RE: Radcliffe Glen - Proposed Amendment to an Approved Subdivision
Proposed Traffic Barrier at Majors Court and University Street
Application ID #2005-0075, CBL #153 A025001

PLANNING BOARD REPORT #49-05

**RADCLIFFE GLEN TRAFFIC BARRIER
HARVARD STREET**

SUBDIVISION AND SITE PLAN AMENDMENT REVIEW

*Barriers to be at intersection of
 Majors Court and University Street.
 Please see site plan application for
 various barrier options*

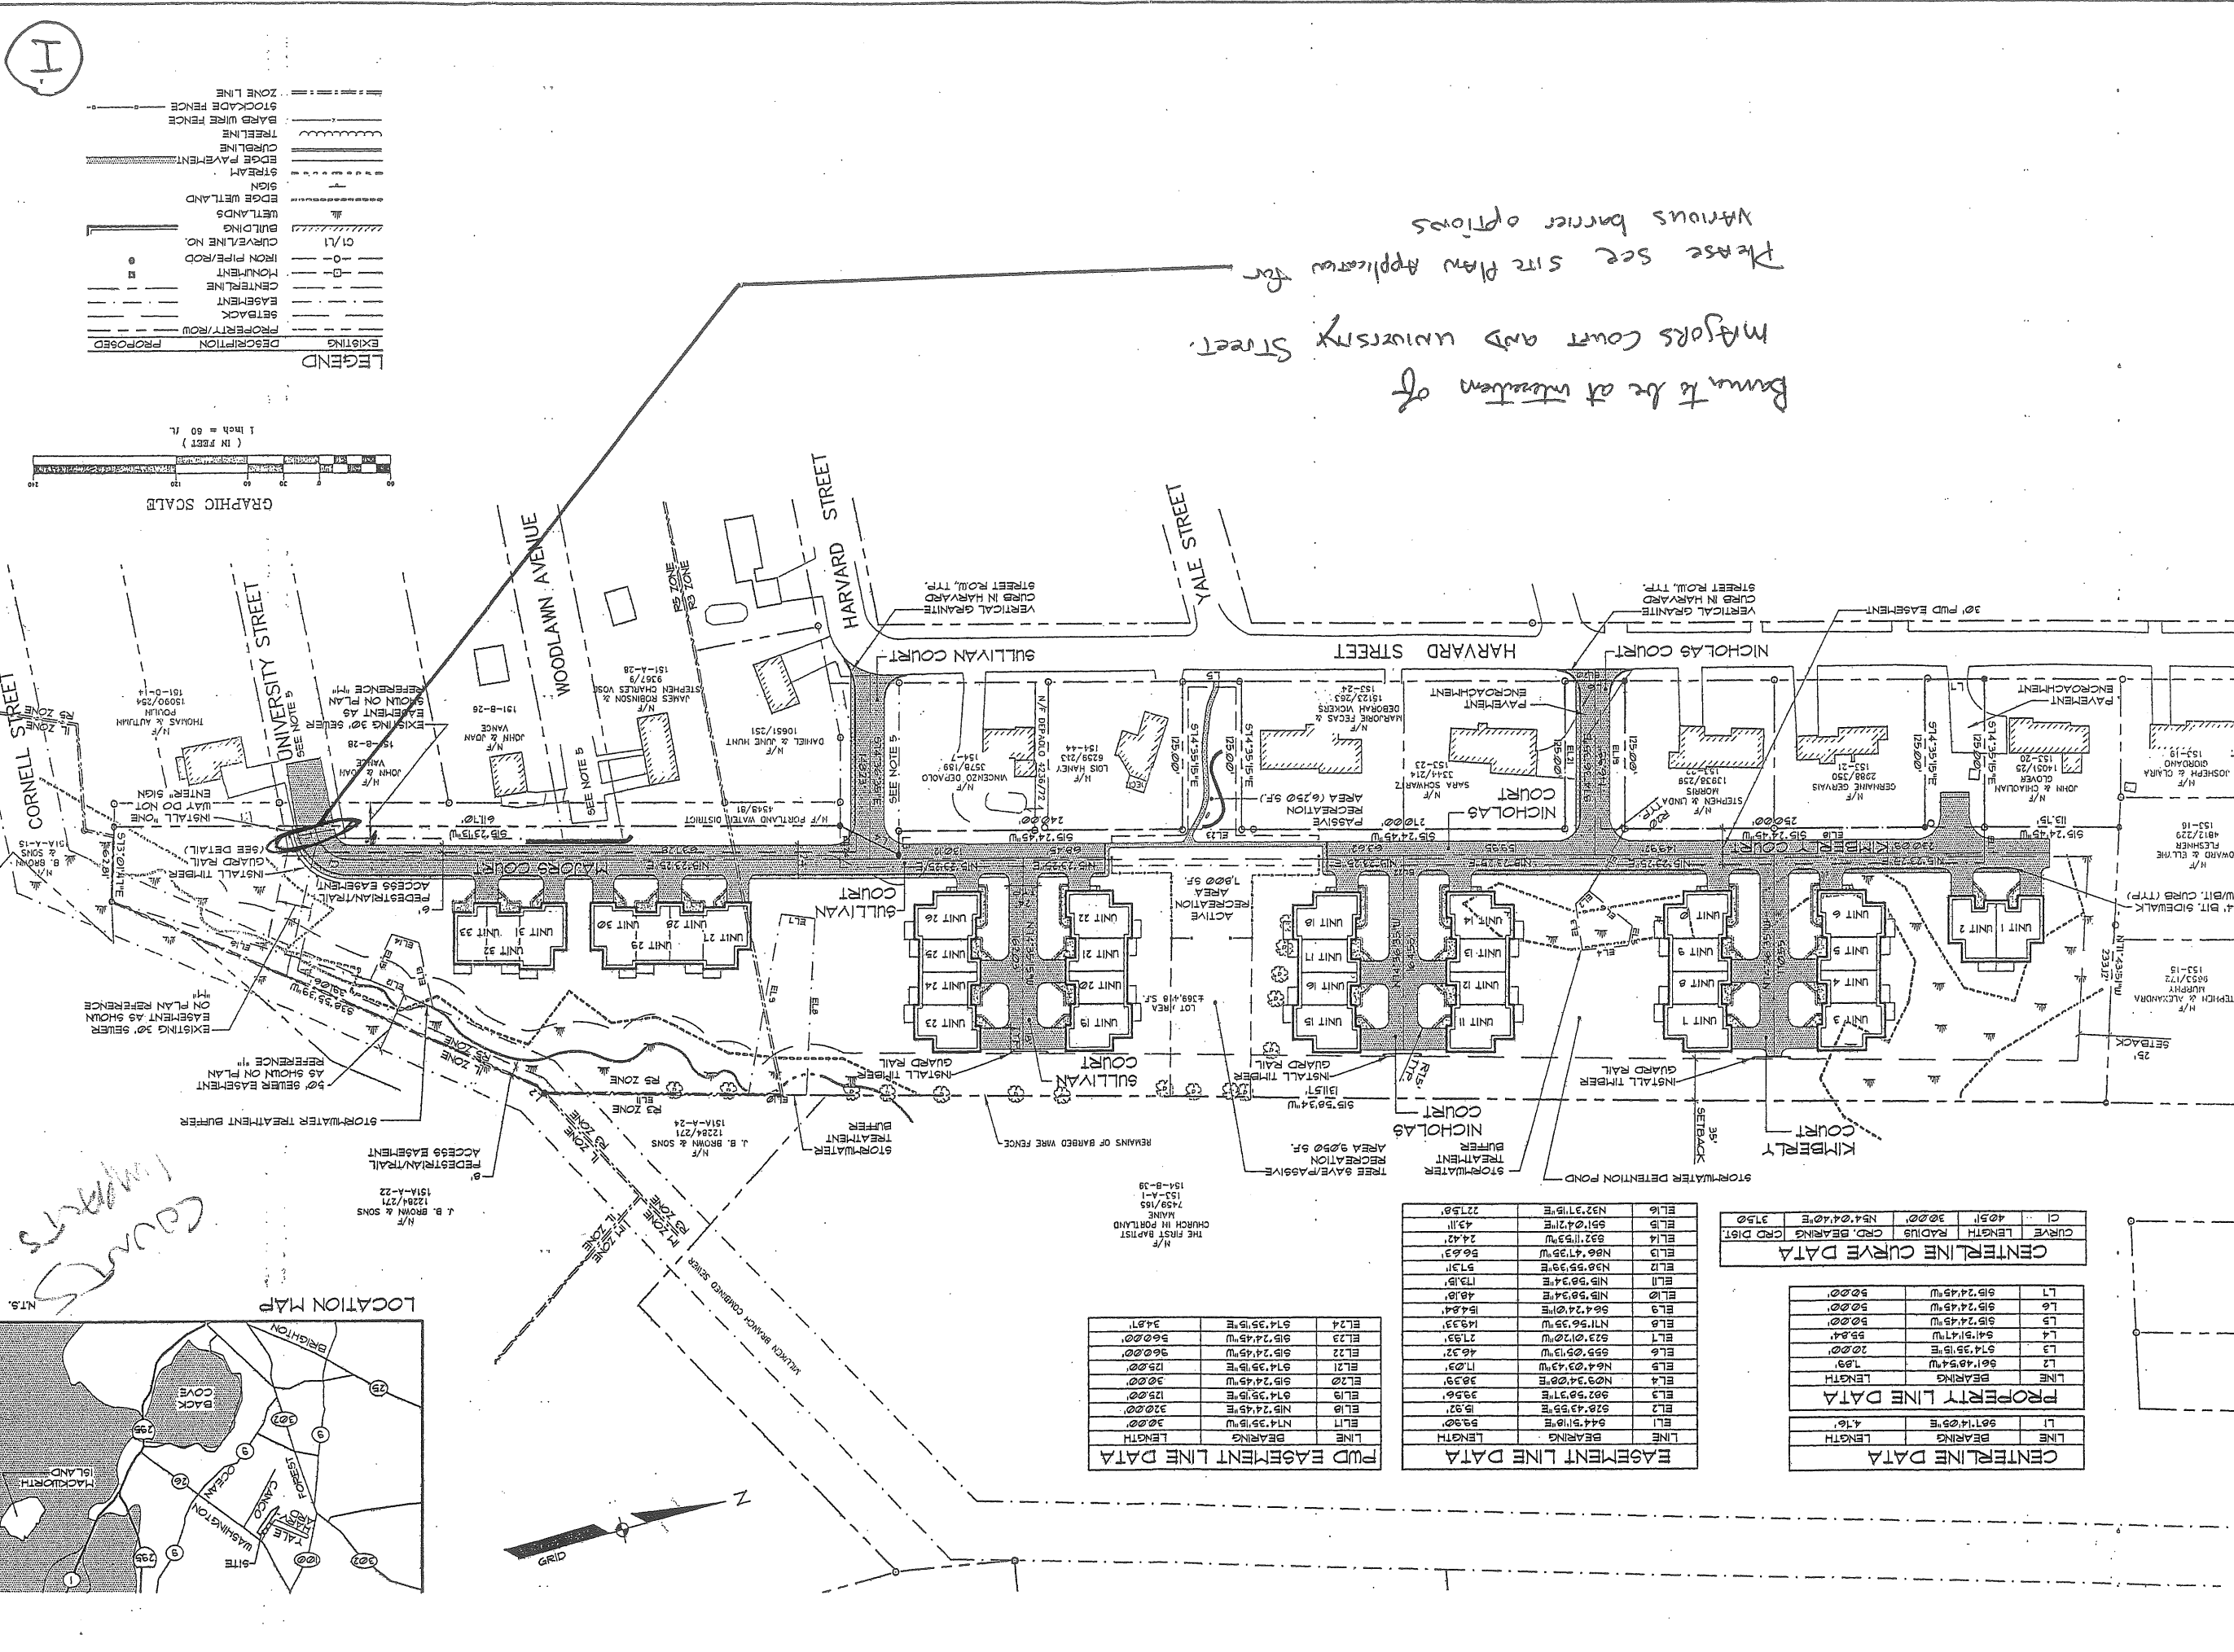
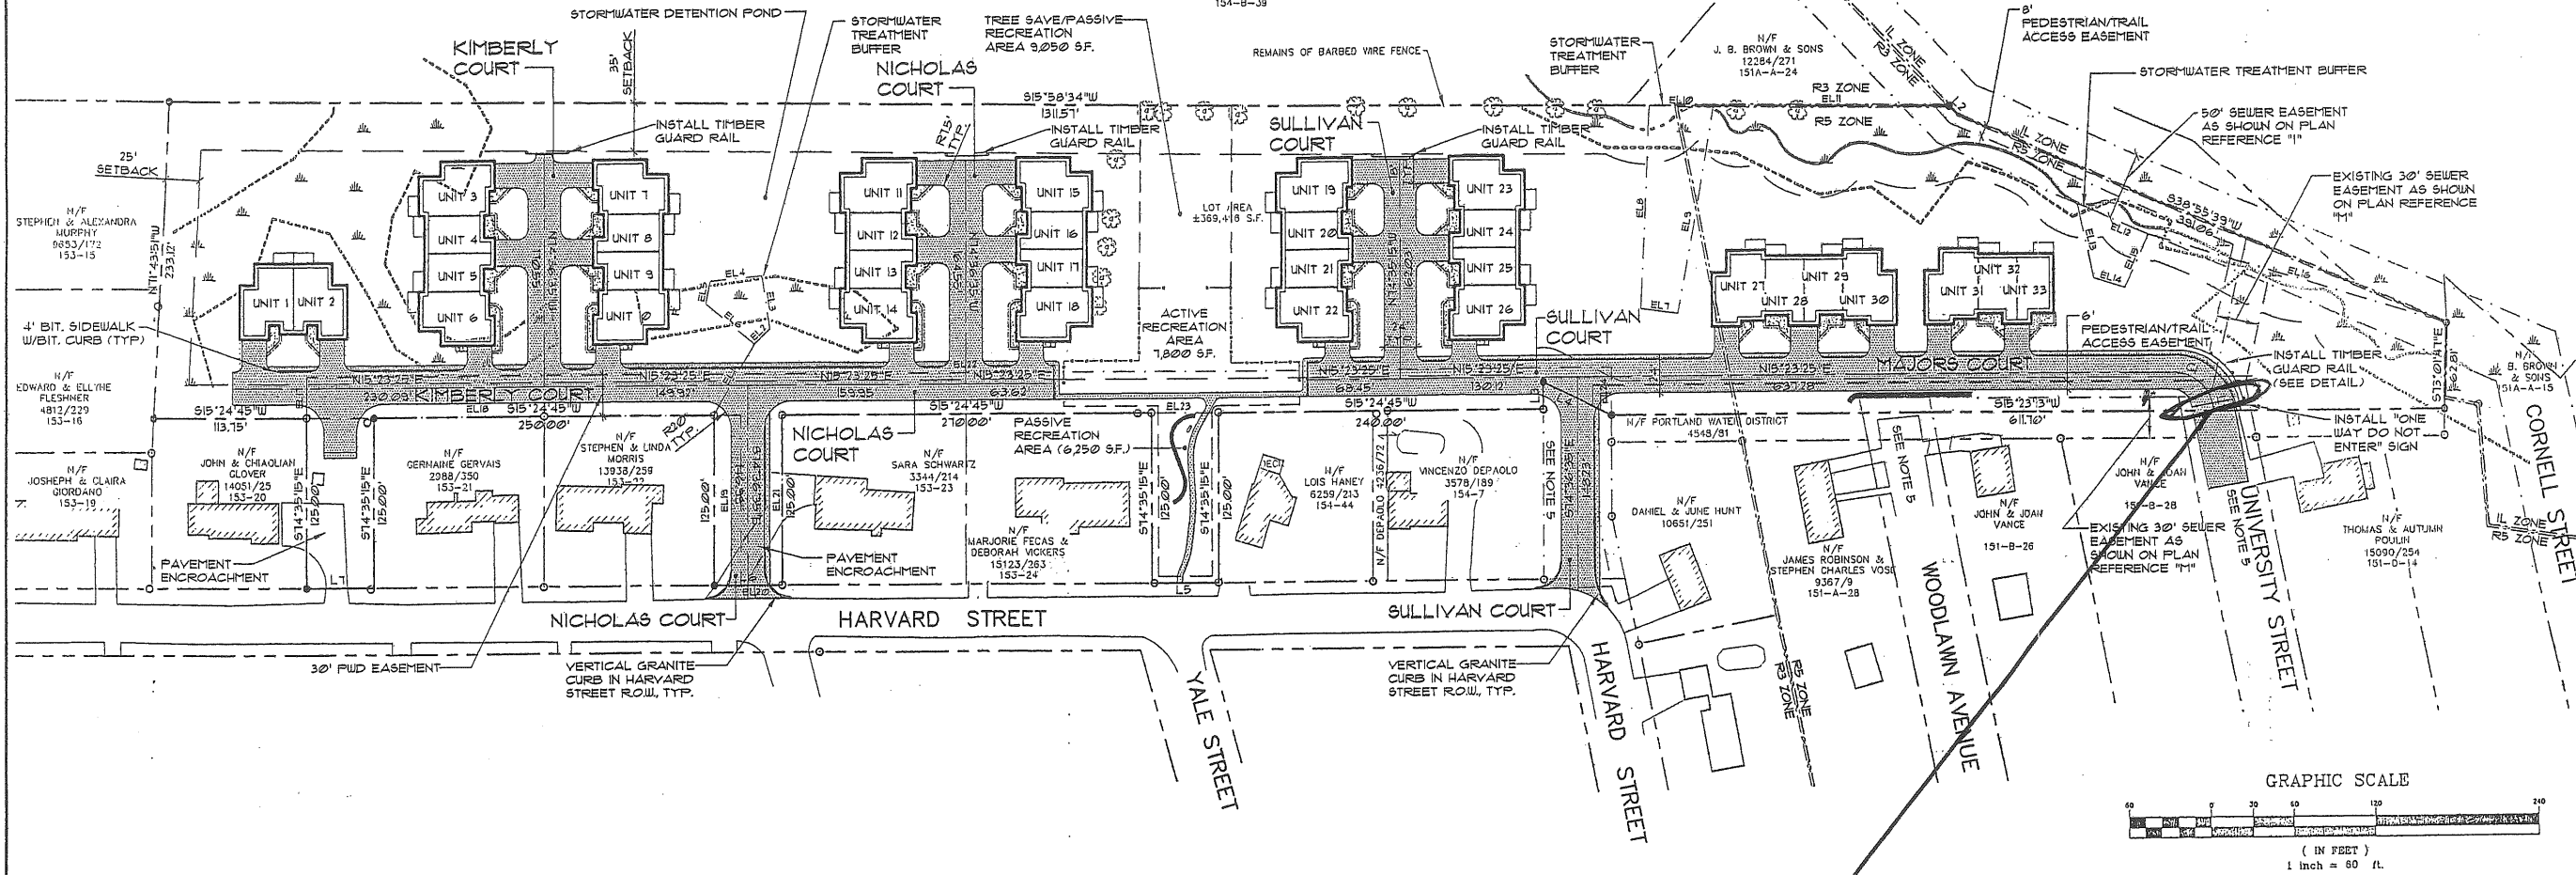
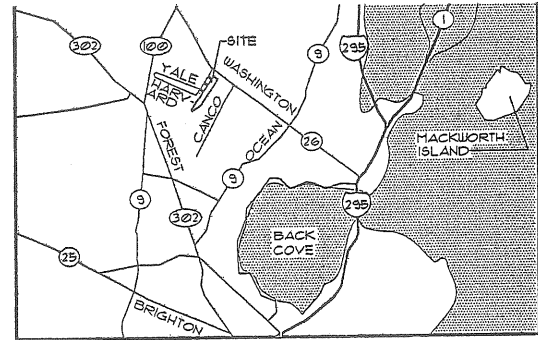
- i. The applicant shall coordinate with the City of Portland Police and Fire Departments to ensure that the proposed barrier is appropriately fitted with a Knox-Lock device or equivalent so that all forms of emergency response vehicles will have access between University Street and Majors Court. The final barrier and Knox-Lock design shall be subject to review and approval by the Planning Authority. The Planning Authority shall review and approve final barrier location consistent with other requirements.

- iii. The applicant shall modify the site plan to provide a public vehicle turnaround at the Eastern terminus of University Avenue in conformance with the City's technical standards and shall grant a public easement to the City over said turnaround. This modification shall be subject to final review and approval by the City Engineer, Corporation Counsel, and the Planning Authority.

- iv. The applicant shall modify the plan to provide an adequate pedestrian connection between Major's Court and University Avenue, if one does not
